File: SF17/26824
Job ID: DOC17/316786
Your Ref: SSD 8126

RE: Heritage Council comments on Redevelopment of UNSW Cliffbrook Campus – Notice of Exhibition. (SSD 8126)

An Environmental Impact Statement (EIS) prepared by Urbis Pty Ltd, dated May 2017, including appendices: Conservation Management Plan (CMP 2017), dated April 2017 and a Heritage Impact Statement (HIS), dated 5 May 2017, both prepared by Weir Phillips and a Historical Archaeological Assessment, dated 3 March 2017 prepared by MDCA, has been reviewed and the following the following comments are provided:

4 PLAN CC3 East Elevation-Demolition 1:100

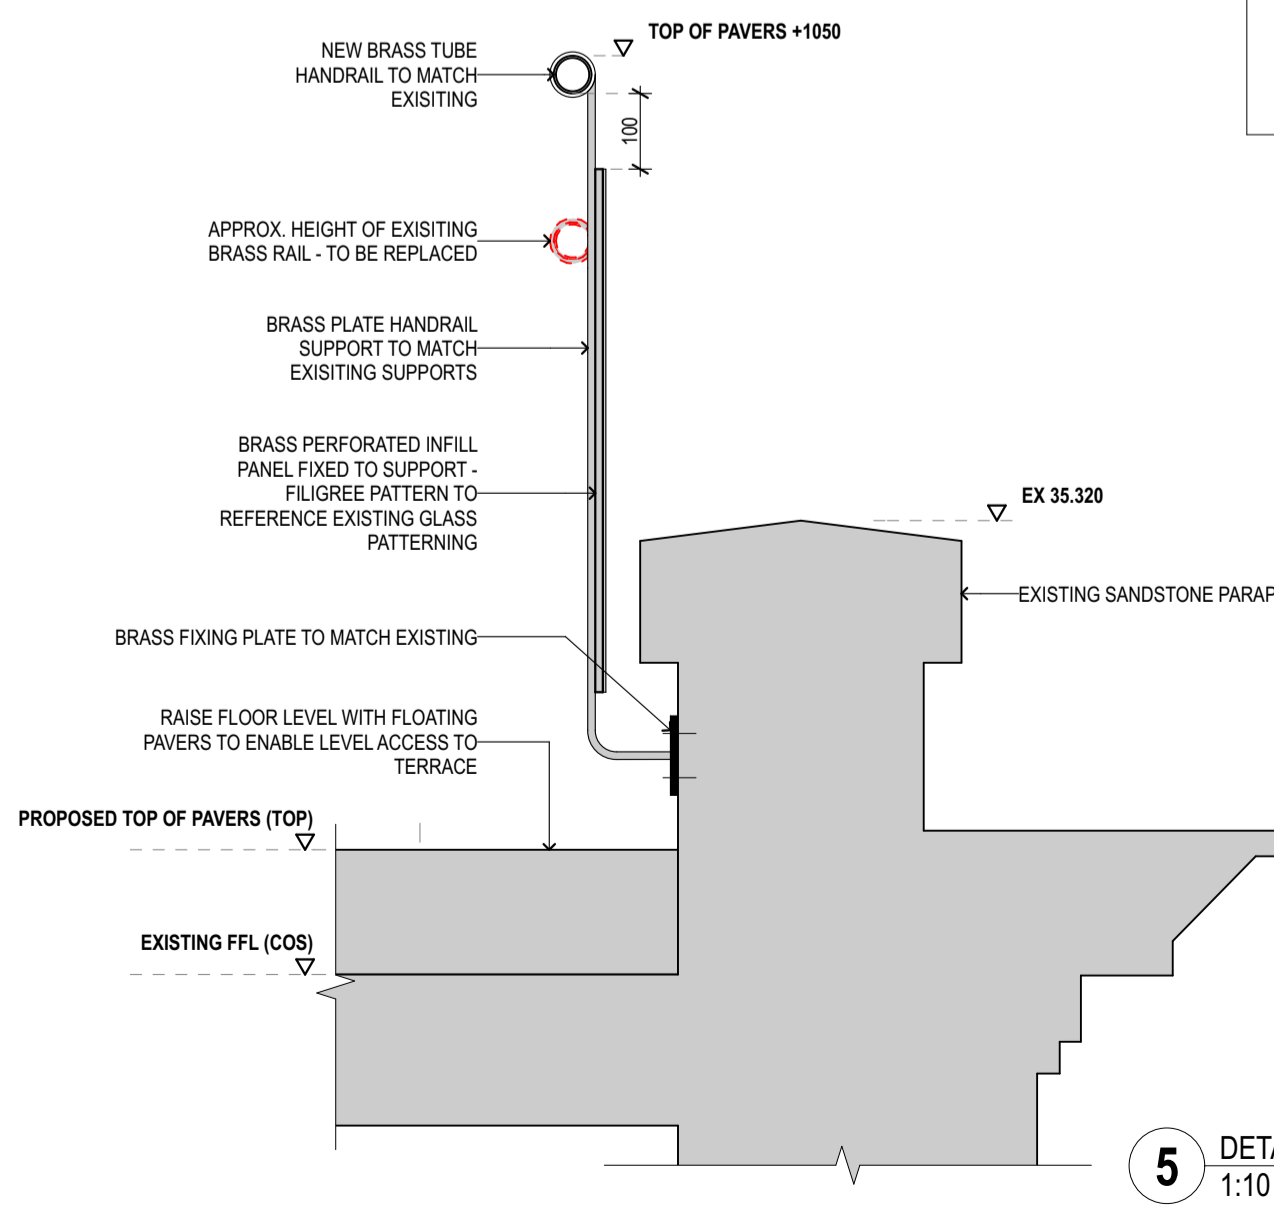
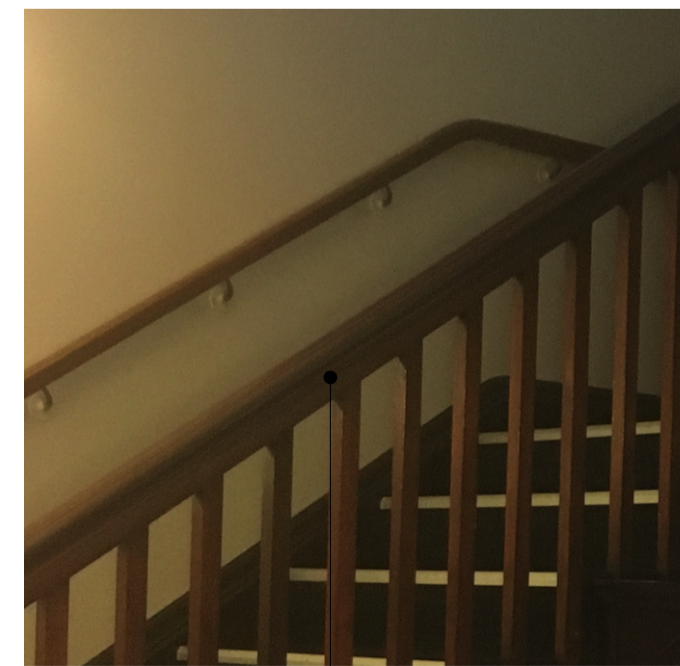
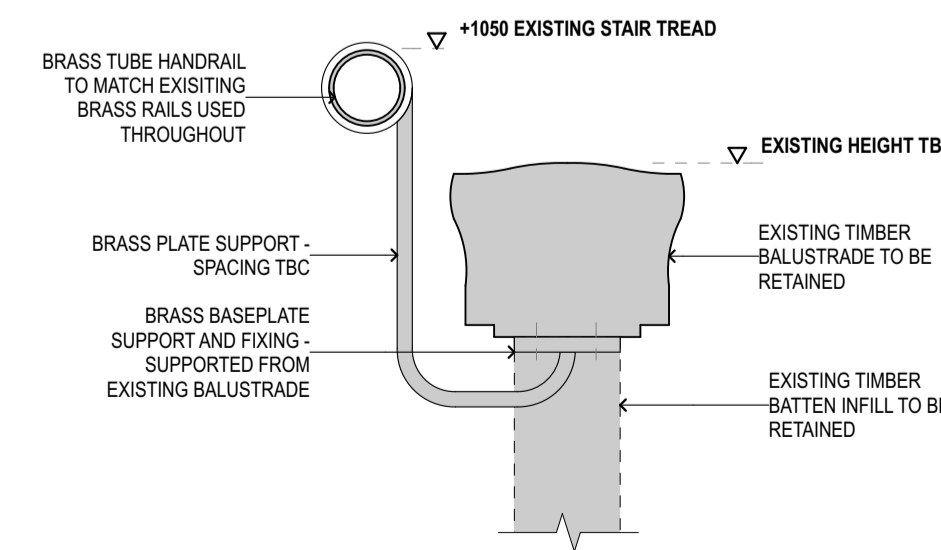
- The alterations to the terraces will not impact significant fabric, the pipe rail and tiling is recent and ranked 'D'- neutral in the HIS. It is suggested that existing fixings to be reused to install new BCA compliant balustrade required to enable access to terraces.

- The removal of the multi-paned window from the ground floor of the north elevation which is original fabric ranked 'A' exceptional unfortunate. However, it is noted that: several options were explored to provide an accessible entrance; the proposed location is within the northern porch on the least prominent elevation of the building; the steel entry platform will be reversible; and the intervention will be clearly detailed as new works while maintaining the width and rhythm of the pattern of fenestration and the sandstone lintel will remain in place. Additionally, no internal walls are required to be removed to provide the proposed access.

- If the proposed removal of the multipaned window is approved, the window should be required to be retained on site and possibly used either in another part of the building or for interpretation purposes.
